WEST SUSSEX COUNTY COUNCIL CONSULTATION

TO:	Arun District Council FAO: Ms Myer
FROM:	WSCC - Highways Authority
DATE:	21 December 2020
LOCATION:	The Cottage Highground Lane Bognor Regis PO22 0BT
SUBJECT:	BN/139/20/PL 1 No dwelling. This application is a Departure from the Development Plan & is in CIL Zone 3 and is CIL Liable as new dwelling.
DATE OF SITE VISIT:	n/a
RECOMMENDATION:	Advice
S106 CONTRIBUTION TOTAL:	n/a

GROUND FLOOR PLAN
1:50

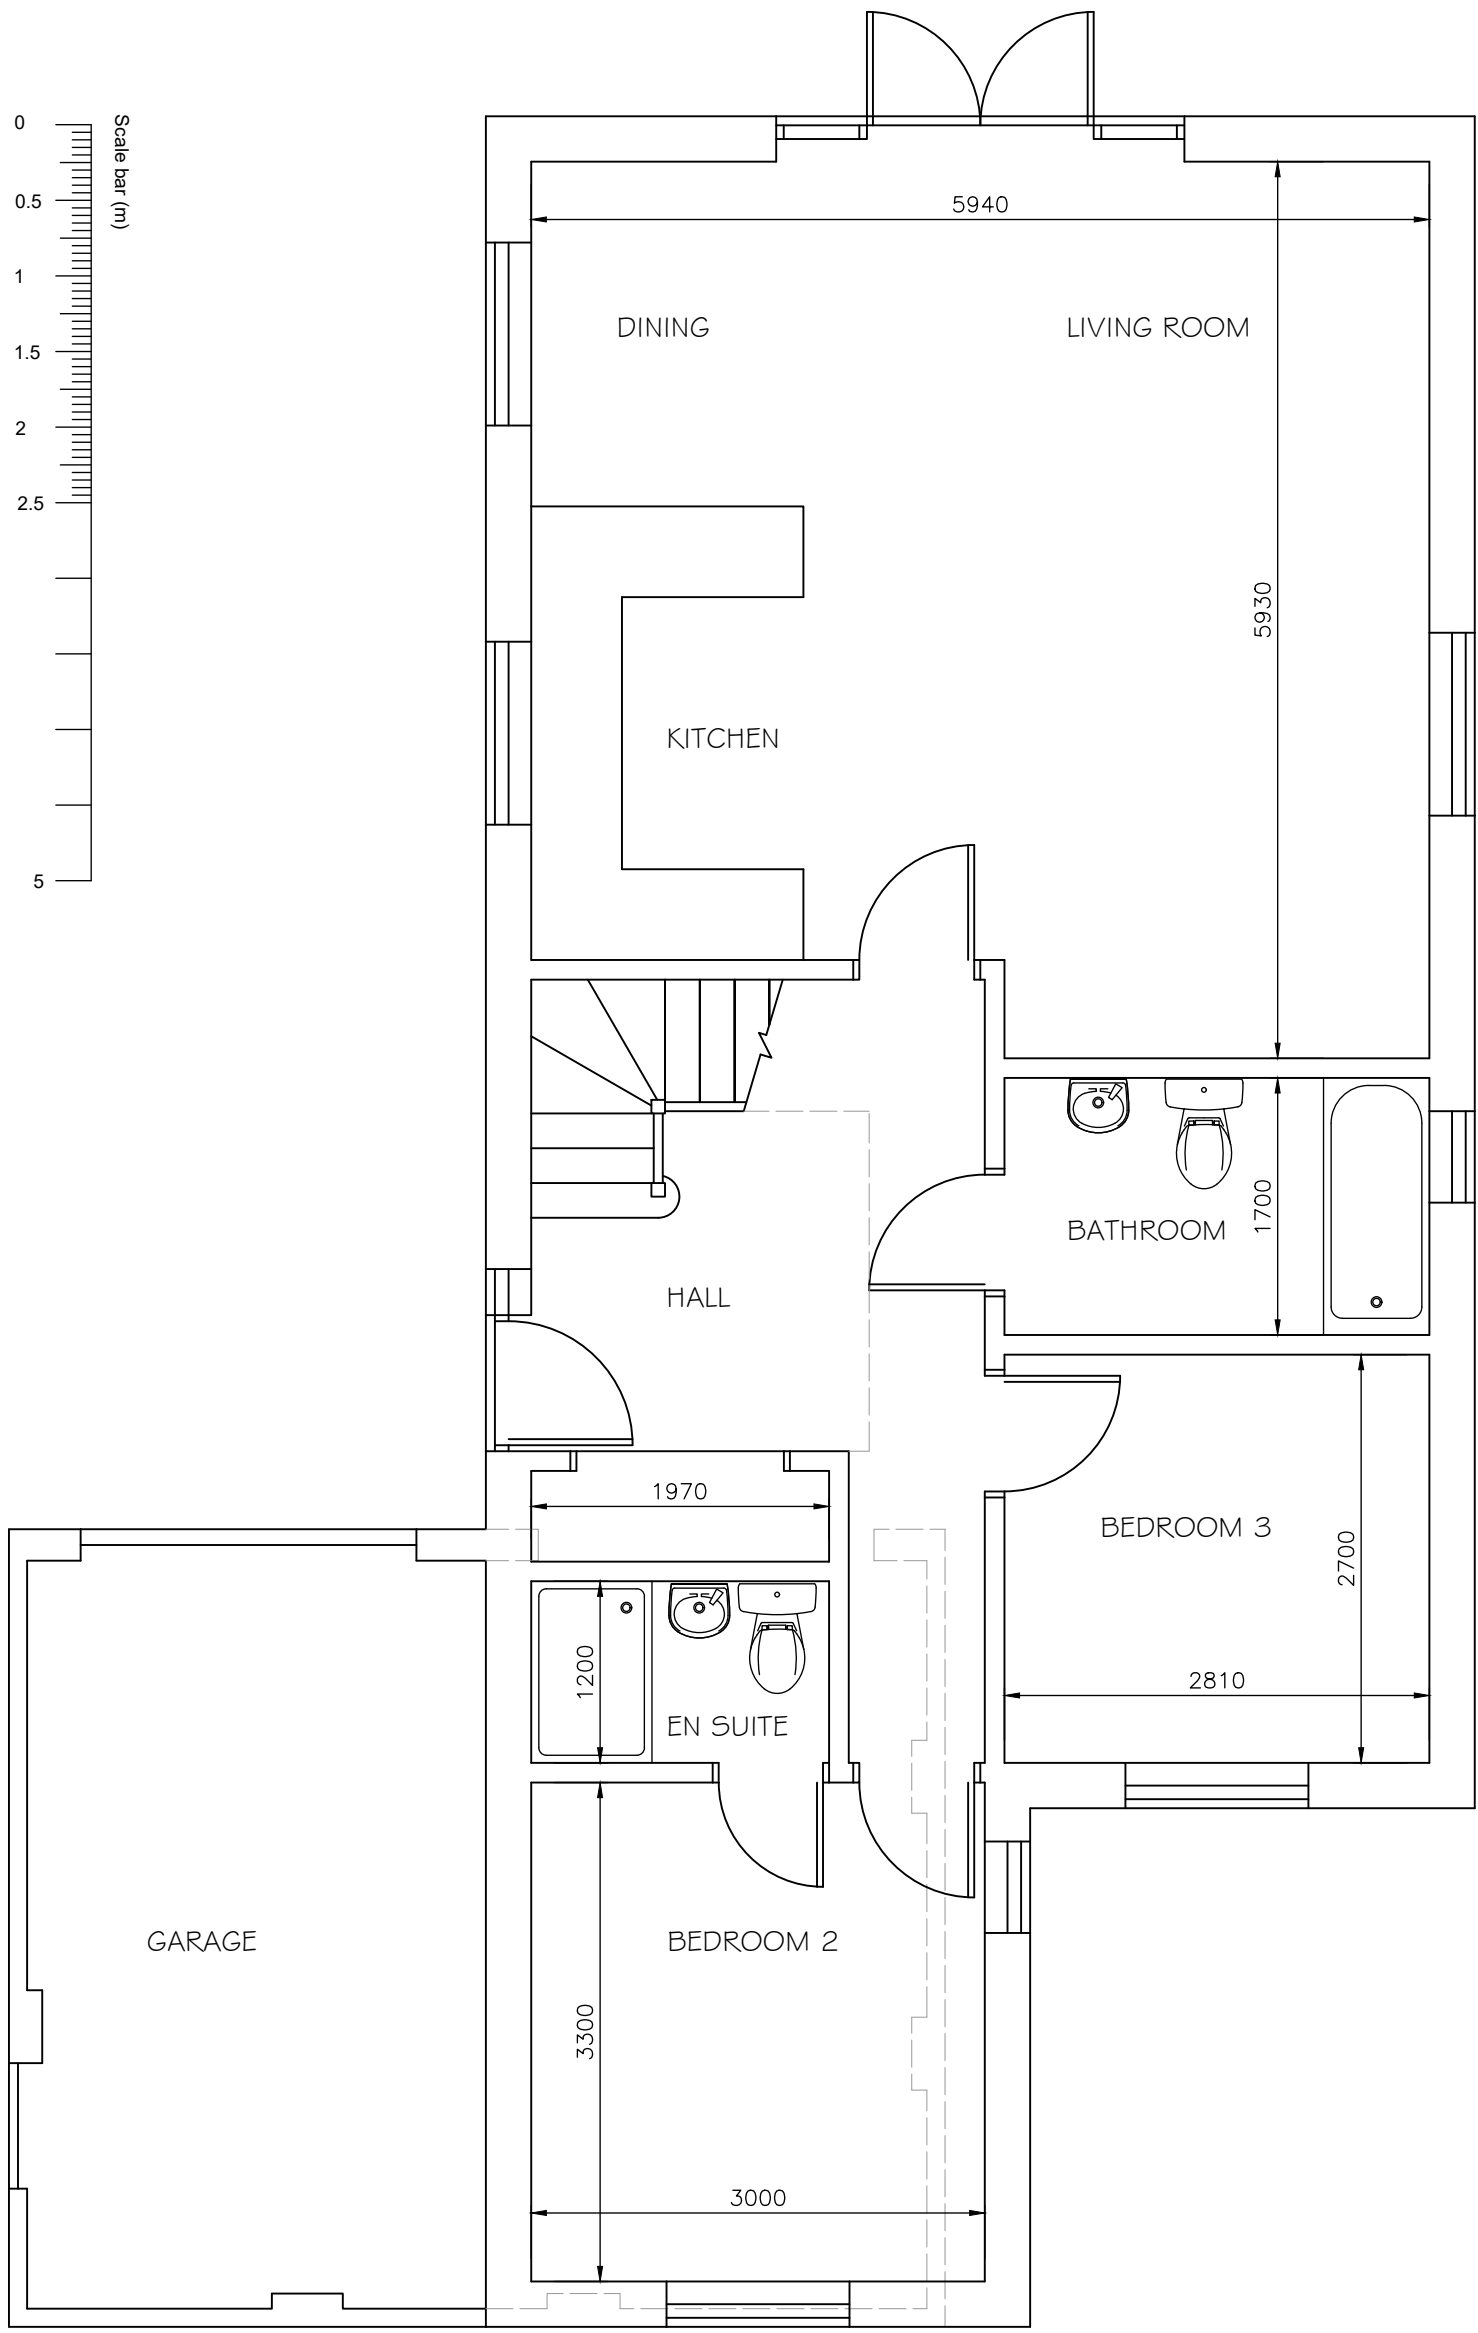
The proposed garage will measure 3 x 5 metres. Garages need to measure 3 x 6 metres in order to be considered a suitably sized parking space, even then they would only count as 0.5 of a space.

The garage can still be considered as a cycle parking provision.

SITE / BLOCK PLAN 1:500

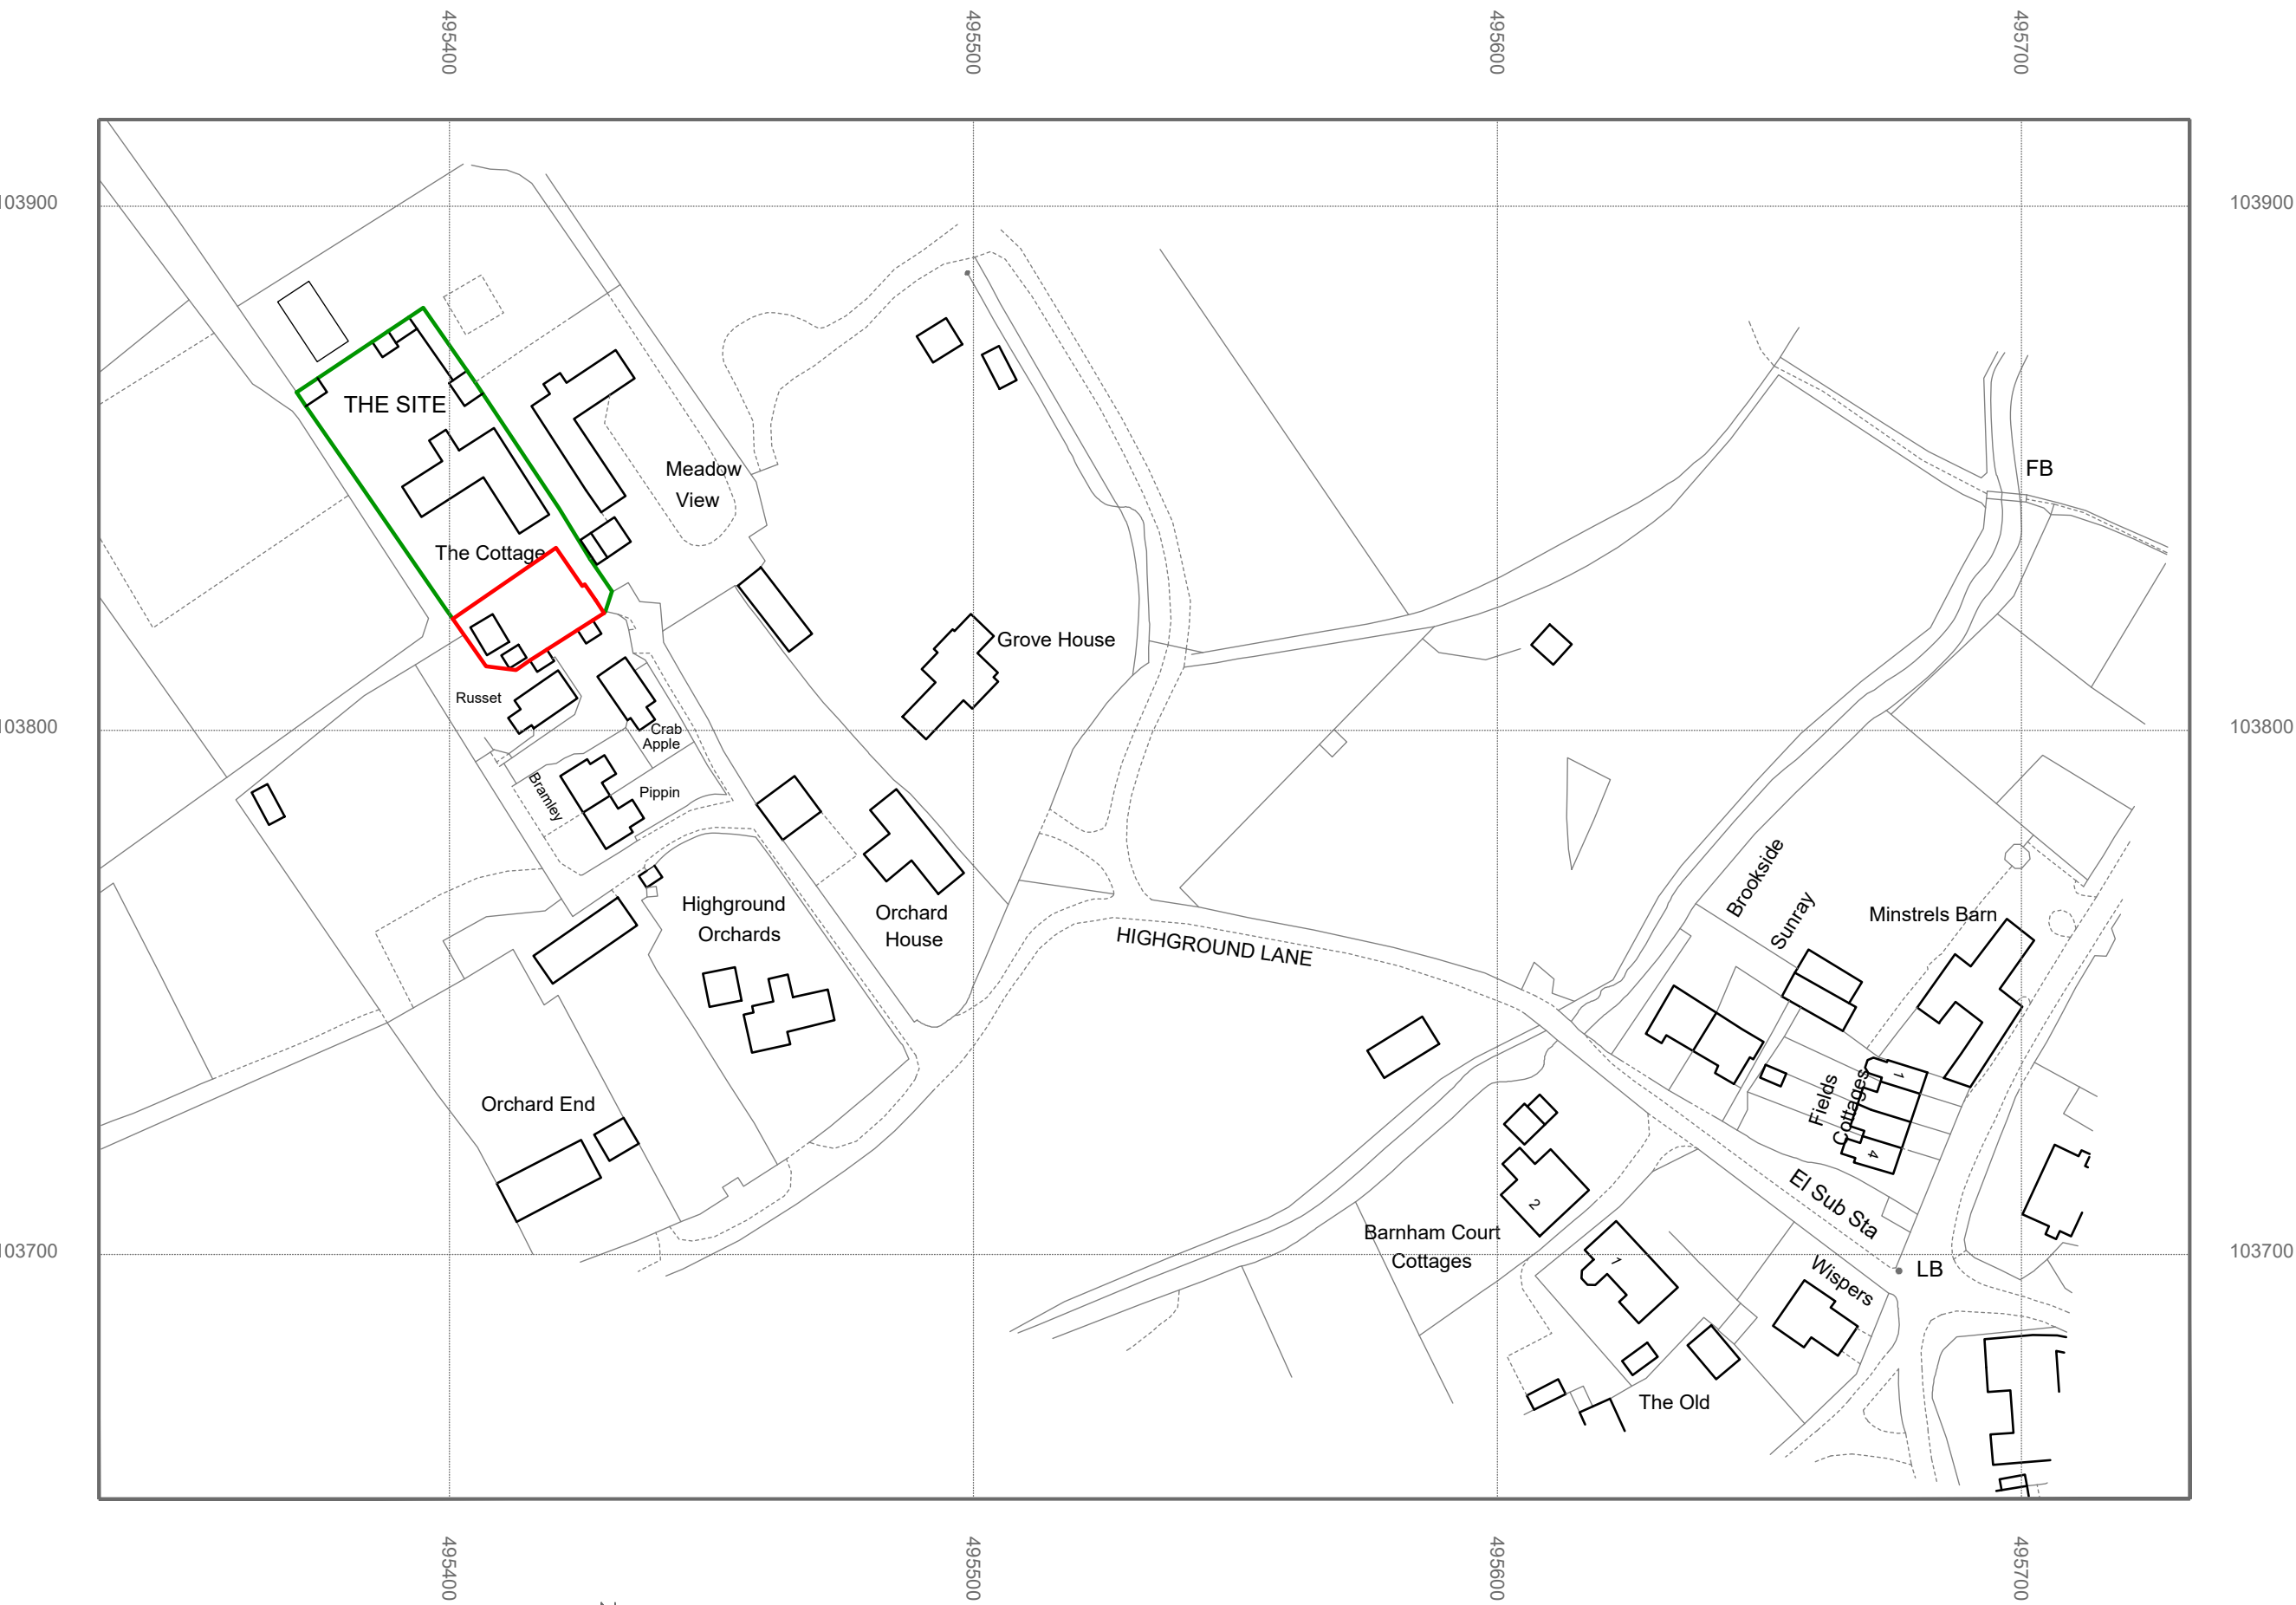
Notwithstanding the above the available proposed hardstanding is large enough to park 2 vehicles and as such a suitable parking provision is provided.

It seems that a suitable length of hardstanding is retained to provide a retained parking provision for The Cottage.
